**Subject: Front Entry Plan Revisions  
126-128 Danforth Street  
Portland, Maine**

Attached please find drawings revisions to the front entry to 126 & 128 Danforth Street. Design incorporates granite cheek wall redesign from 2" thick veneer panels & granite caps to solid 16" thick granite cheek wall blocks and structural foundation design.

BUILDING LOCATED AT
126/128 DANFORTH STREET
PORTLAND, MAINE
FRONT ENTRY ROOF/DECK REPAIR
SECTIONS AND DETAILS

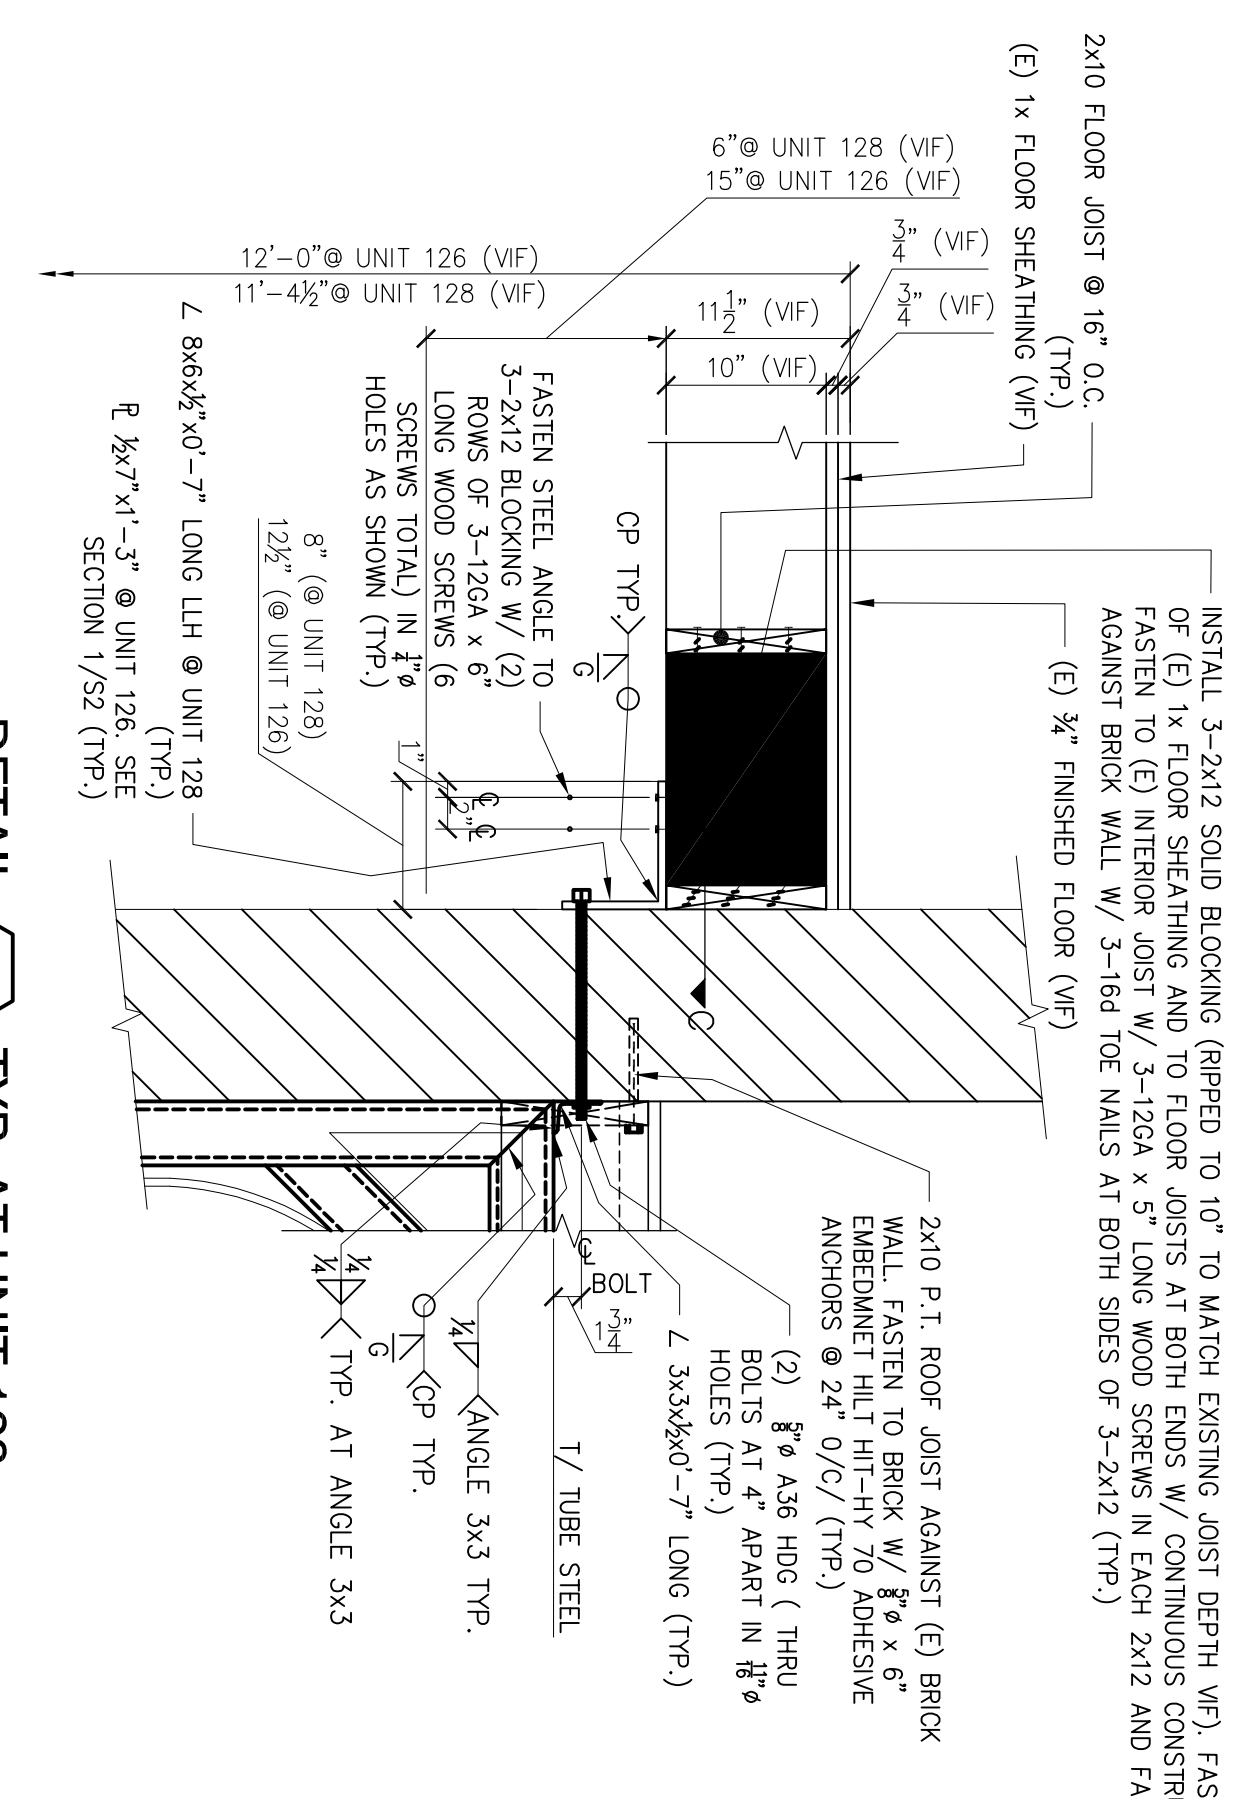
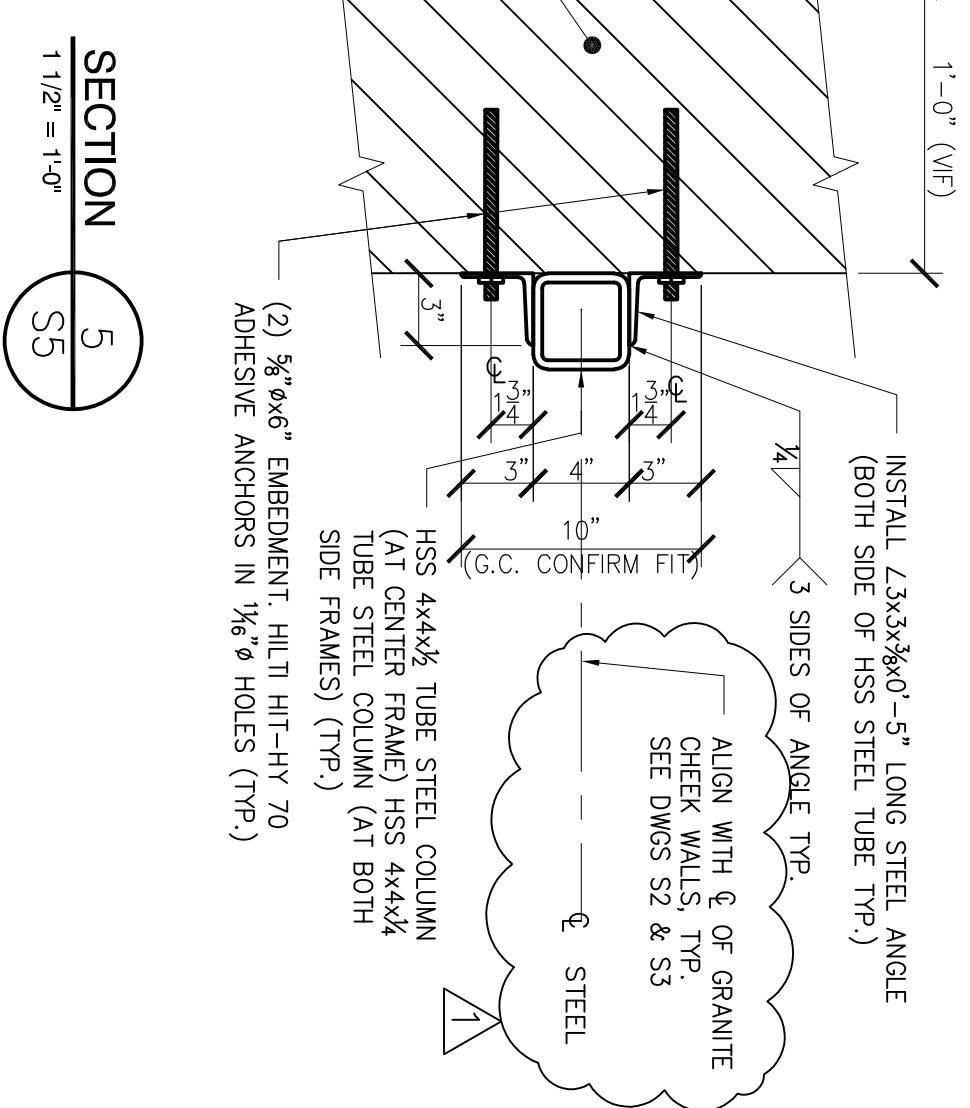
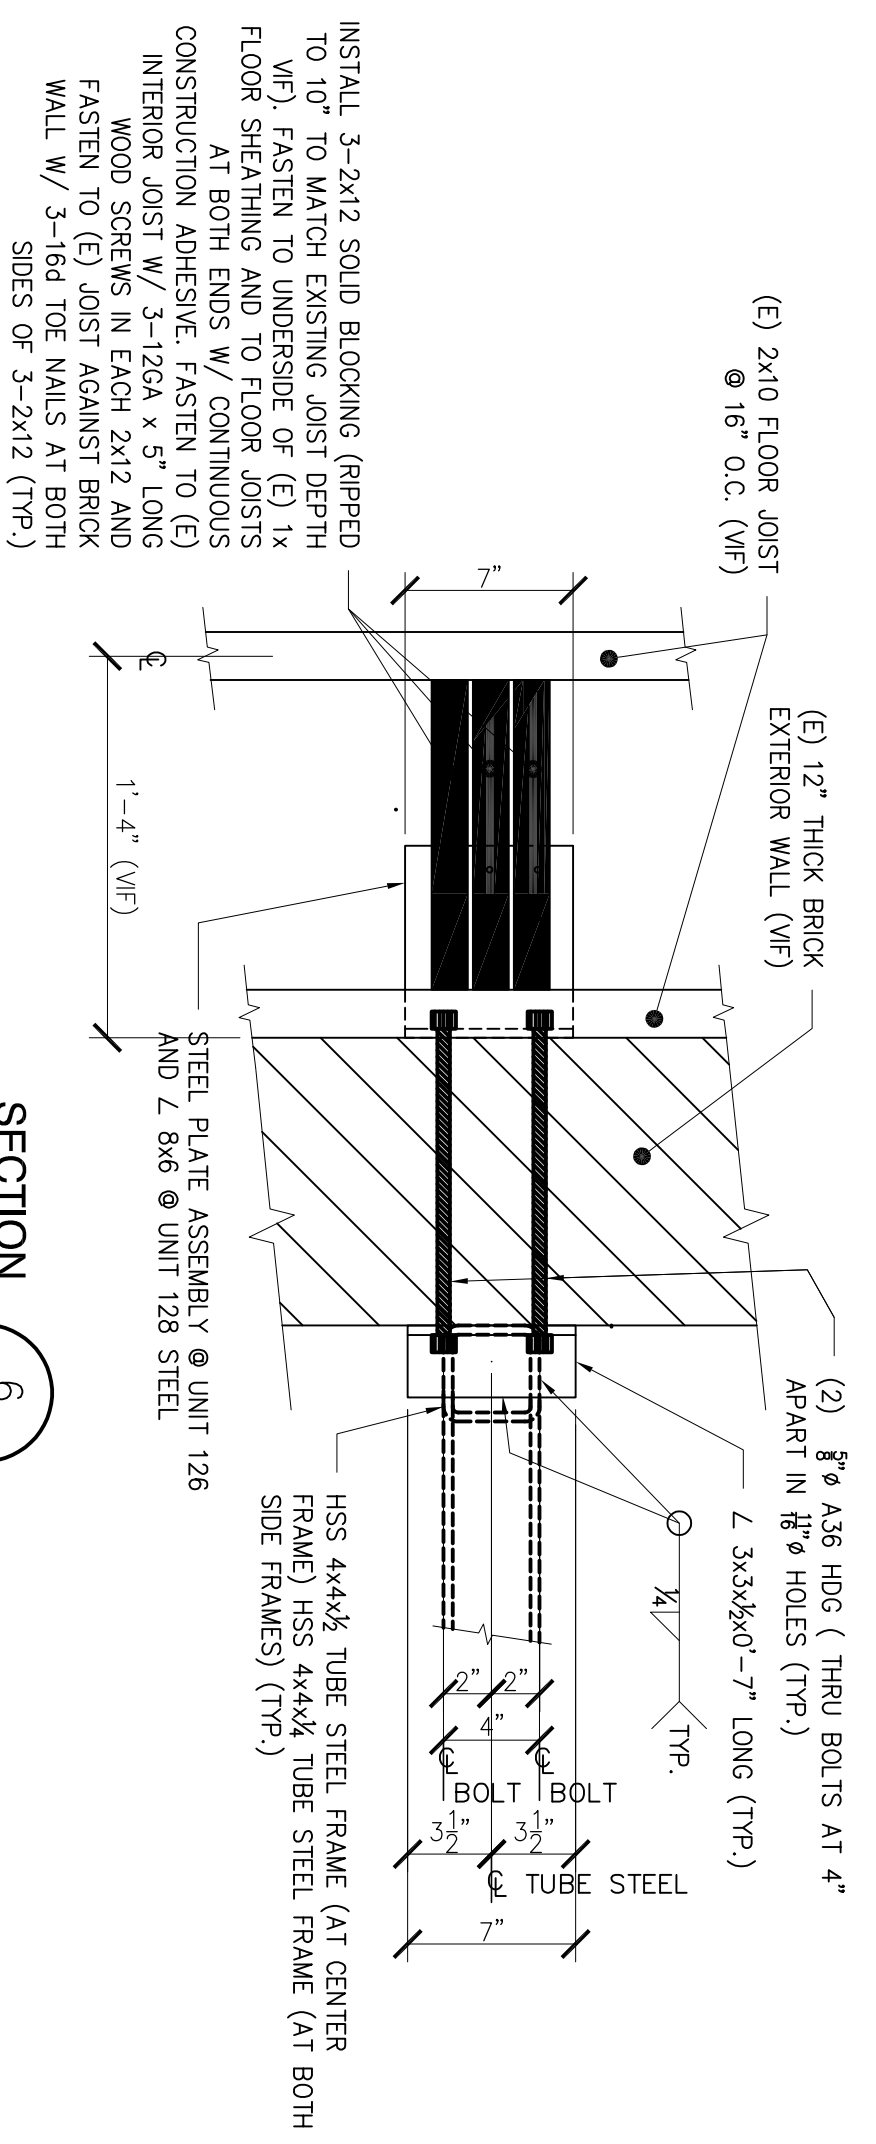
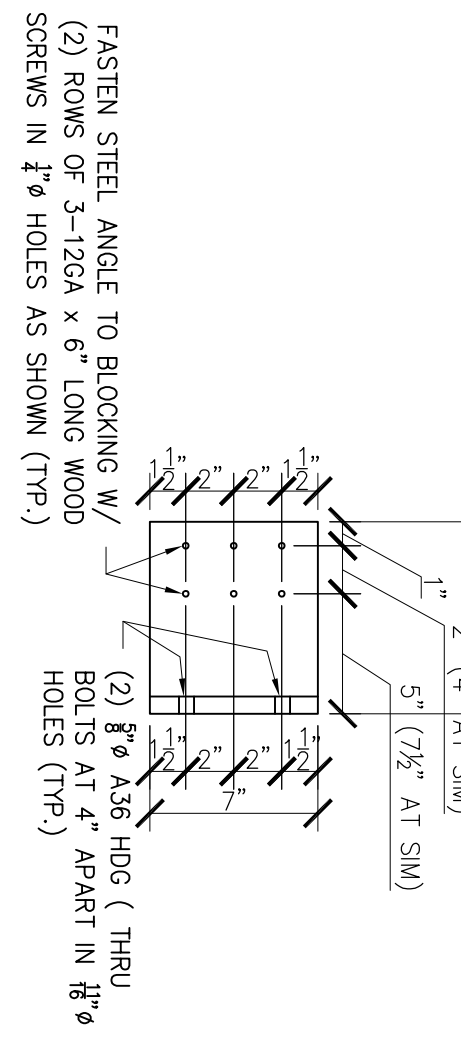
Drawings revised : **A2, A3, A5 and S1, S2, S3 and S5**
